1 April 2022

SSD-10360337 – ST PHILLIPS CHRISTIAN CESSNOCK COLLEGE – ALTERATIONS & ADDITIONAL AND INCREASE TO 1,732 STUDENTS - 10 LOMAS LANE & 210 WINE COUNTRY DRIVE NULKABA

I refer to the request by the Department of Planning, Industry and Environment (DPIE) dated 15 February 2022 seeking input from Transport for NSW (TfNSW) to the Environmental Impact Statement (EIS) for the abovementioned development proposal.

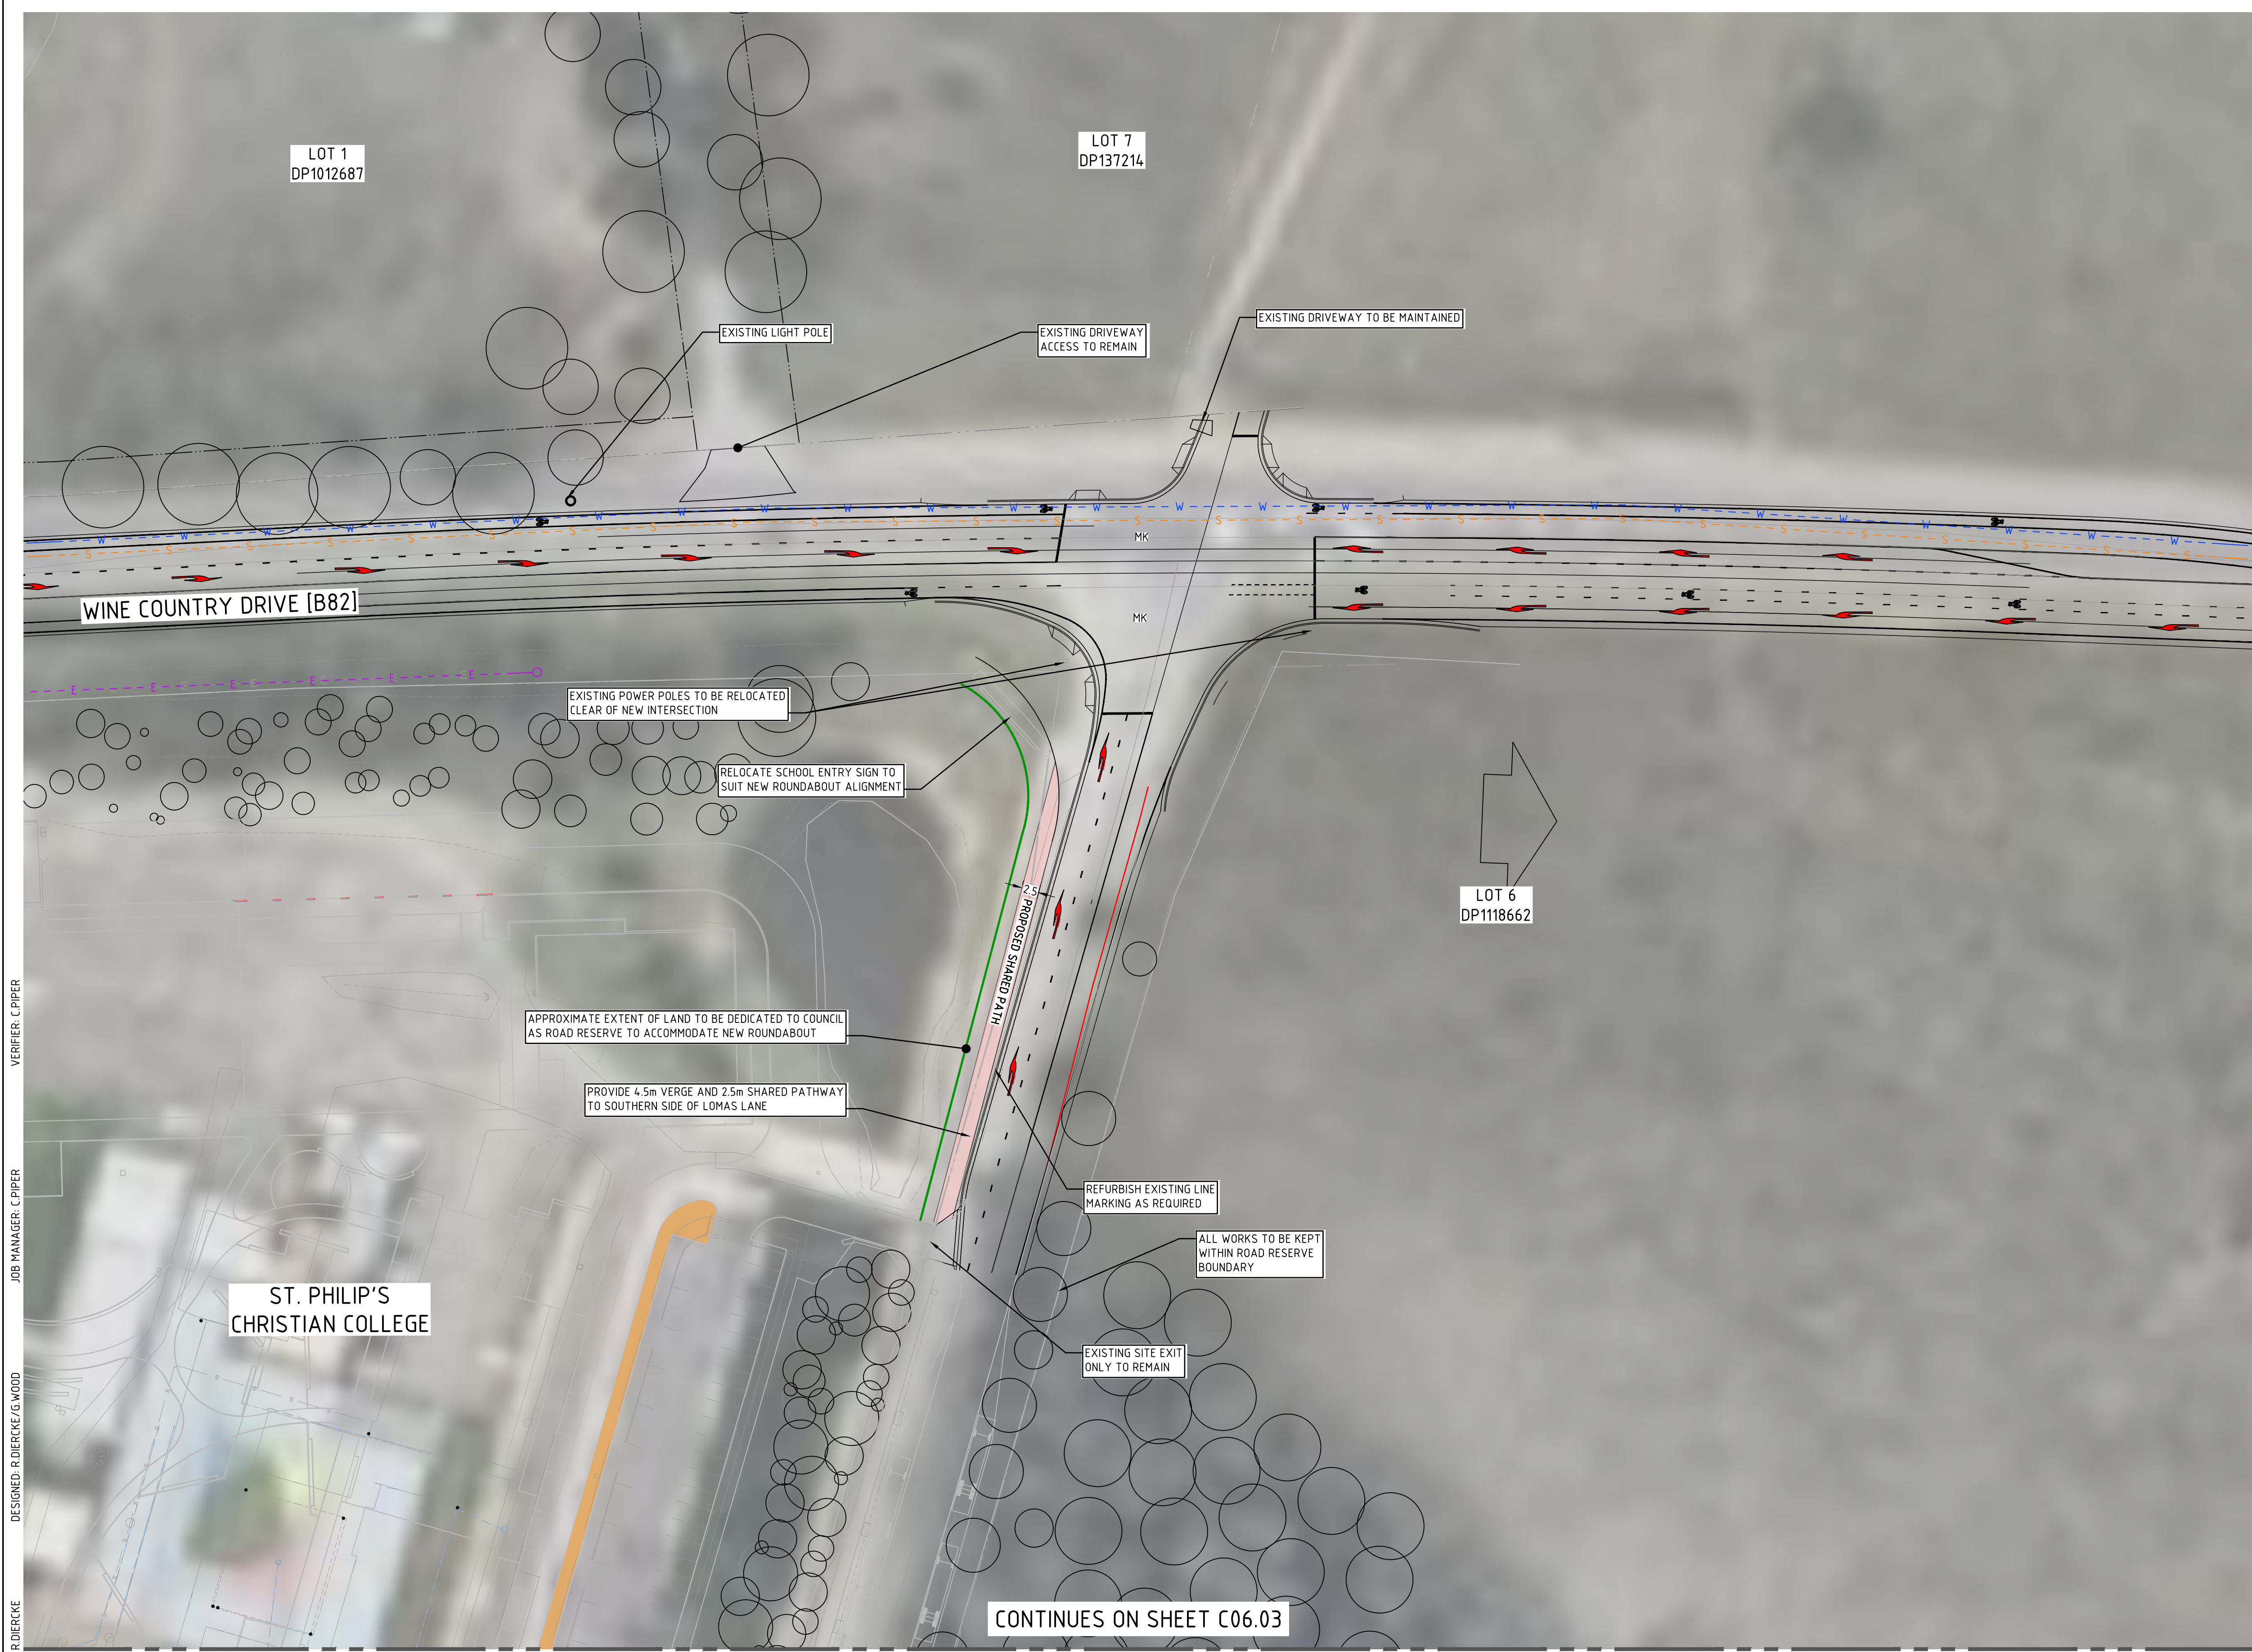
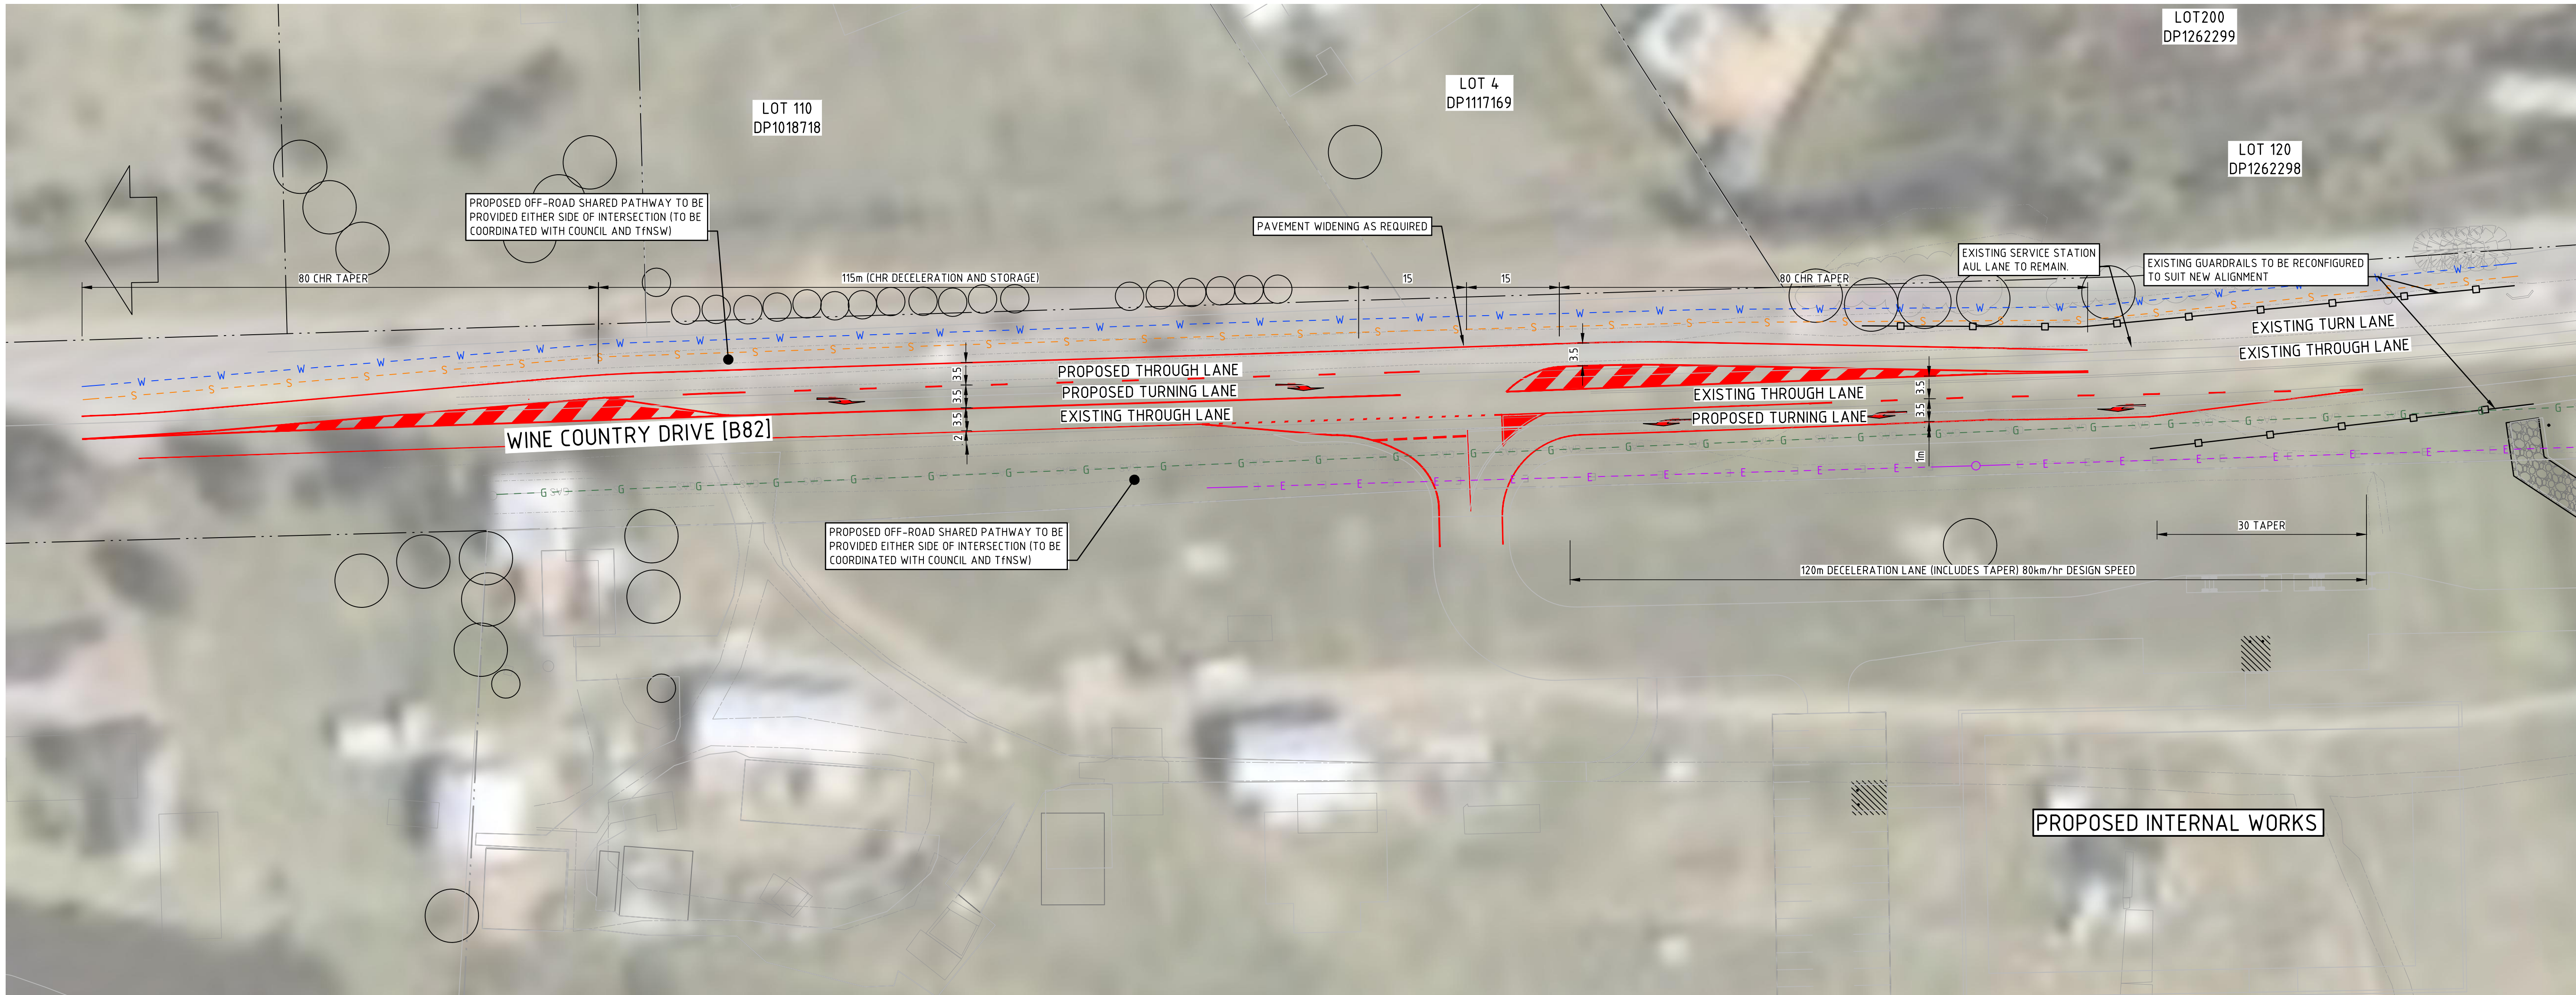
- General design comments on the civil works layout are provided for consideration and will impact upon the scope of the subject development:
 - It seems that to achieve the satisfactory LOS indicated in the submitted SIDRA report, the roundabout would require 2 lanes through the roundabout into a merge after the exits in both directions to perform adequately.

- To slow vehicles on WCD approaching the roundabout more effectively, the Deflection should be increased on the roundabout entry similar to Austroads Part 4b) Page 23.
- The roundabout should consider on road cyclists and pedestrian refuges in the splitter islands
- The proposed roundabout can be constructed from Concrete however would accept if this pavement was converted to a Heavy-Duty Flexible Pavement if required for constructability
- A shoulder width of 2m should be included for the WCD access intersection.
- Neighbours submission - If the roundabout is designed in accordance with Austroad's then it is safe to have a property access off one of the roundabout legs.
- DPIE Enquiry - The design for the roundabout needs to consider the existing shared entry / exit access driveway servicing 307-311 Wine Country Drive.
